ENG-PUDSP20005-R6-CD-Util-redlines.pdf Markup Summary

# U1.2

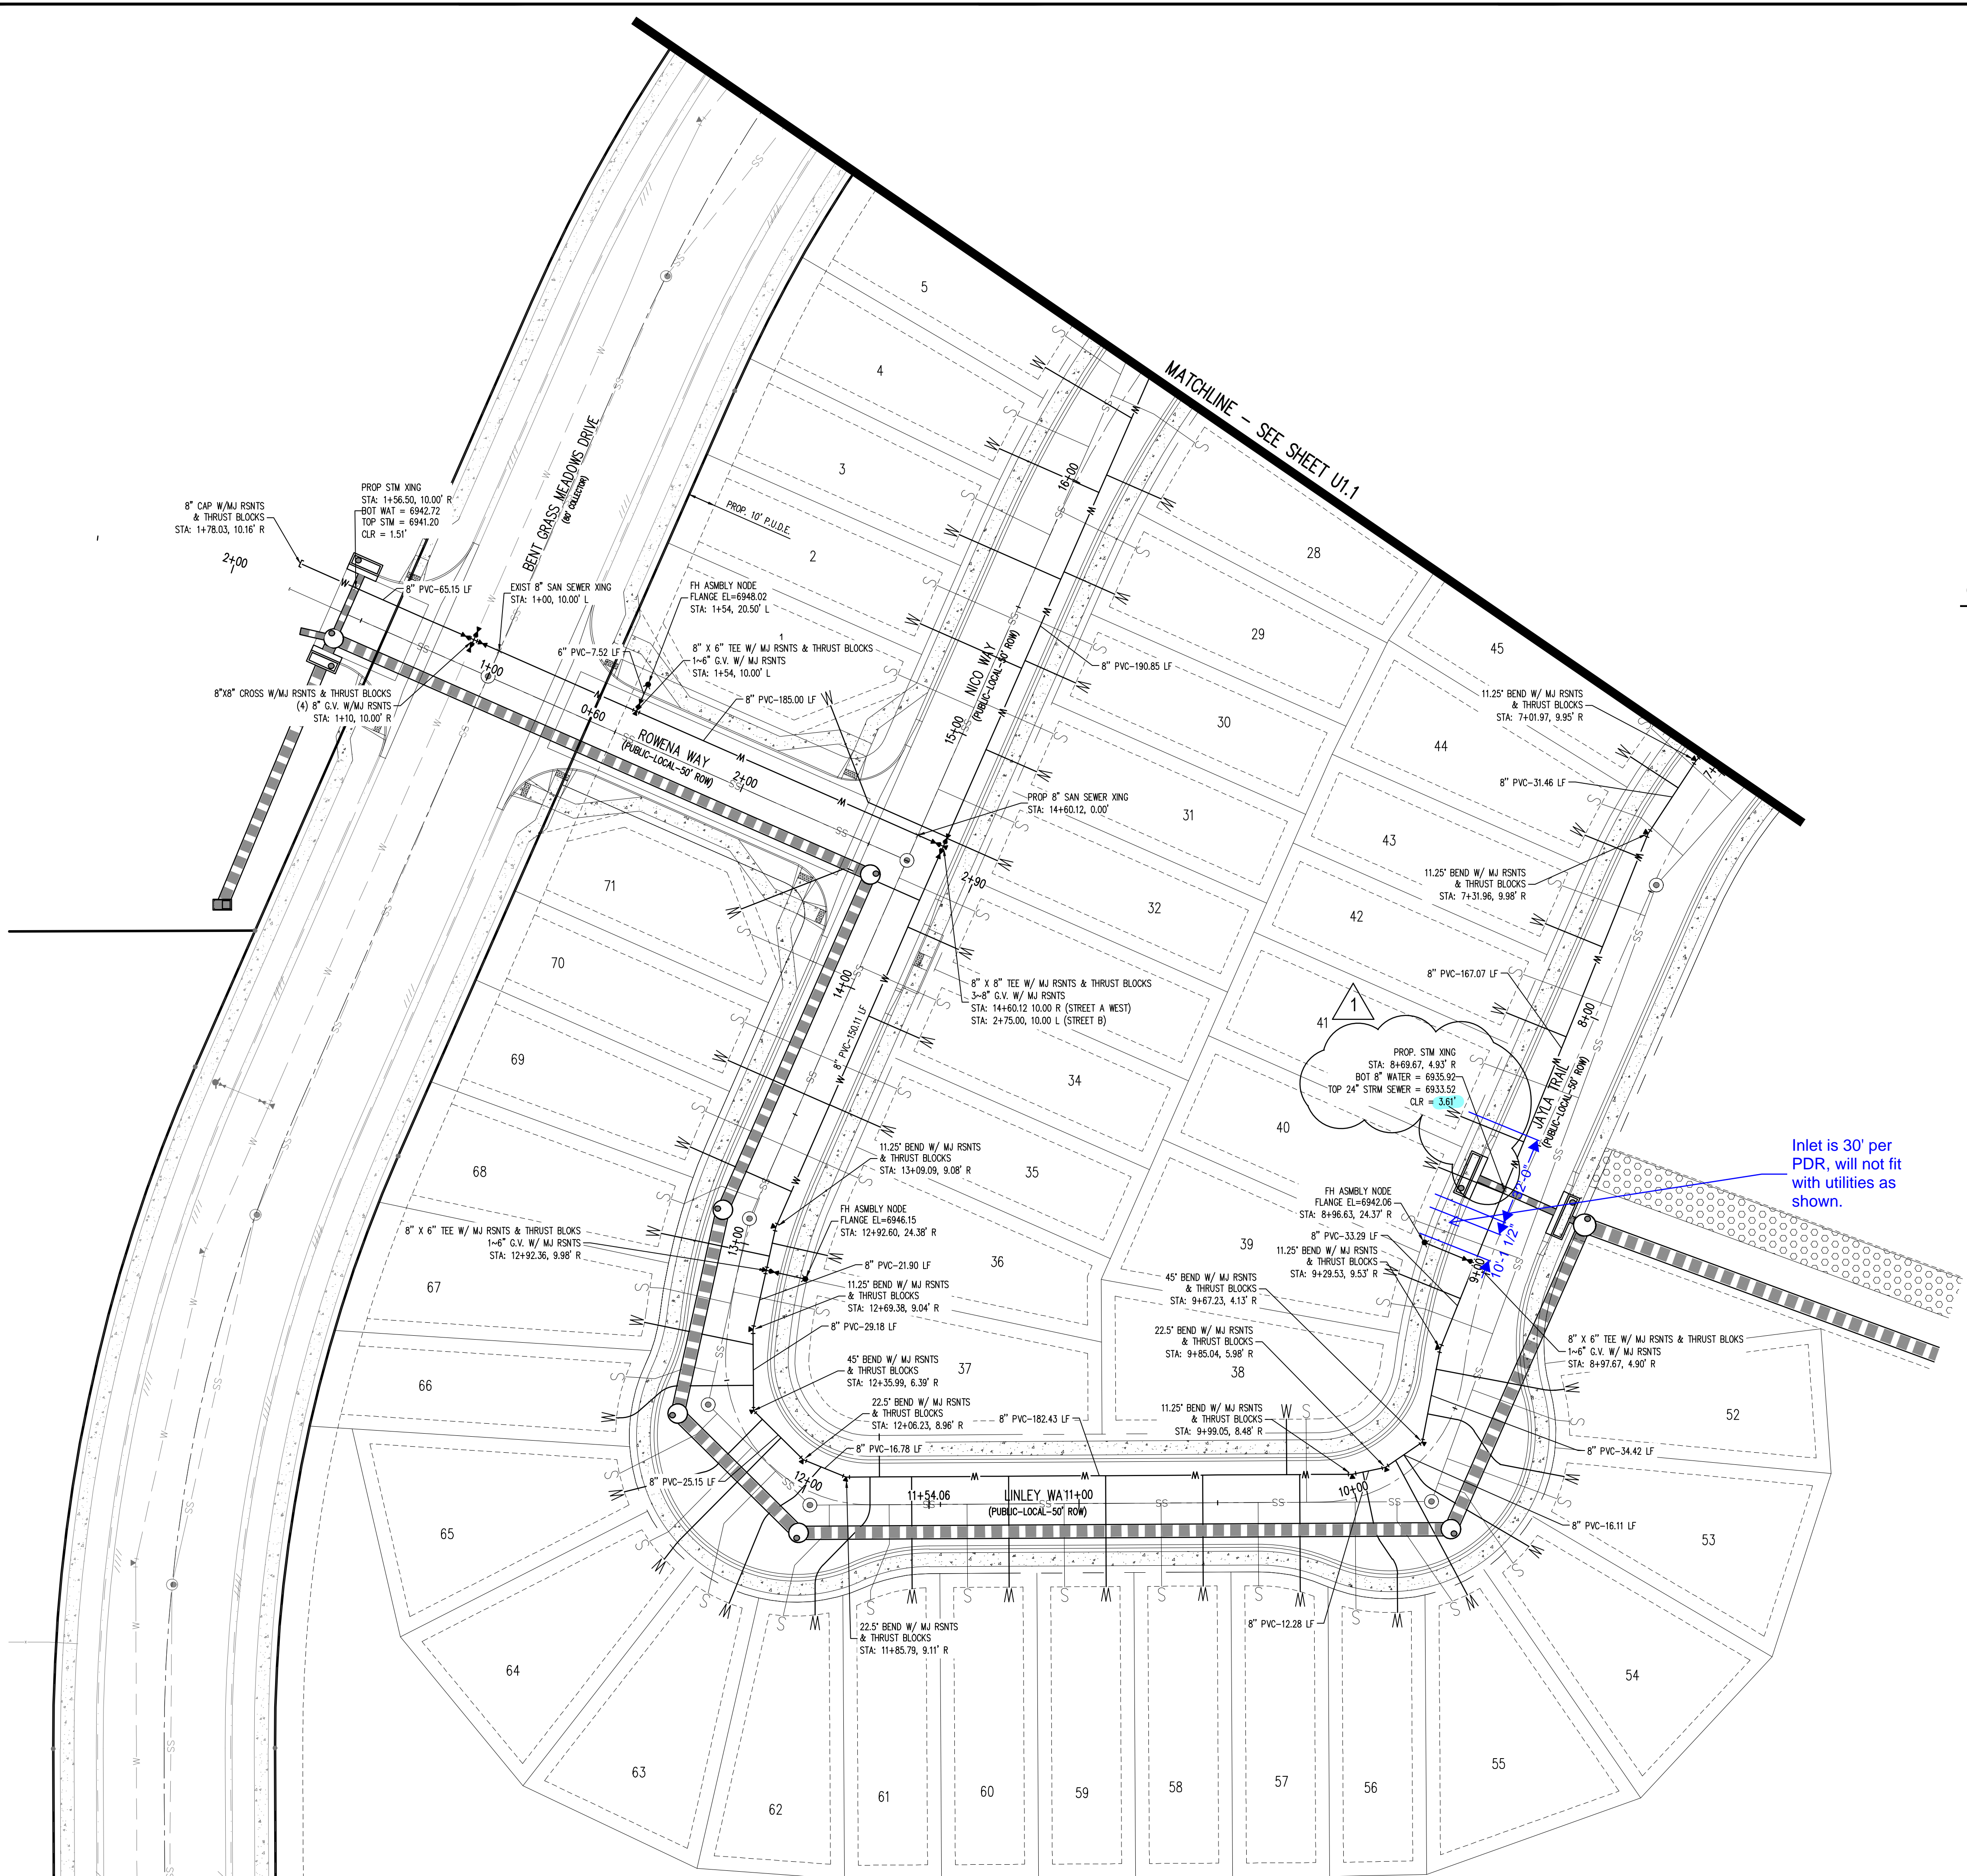
Inlet is 30' per PDR, will not fit with utilities as shown.
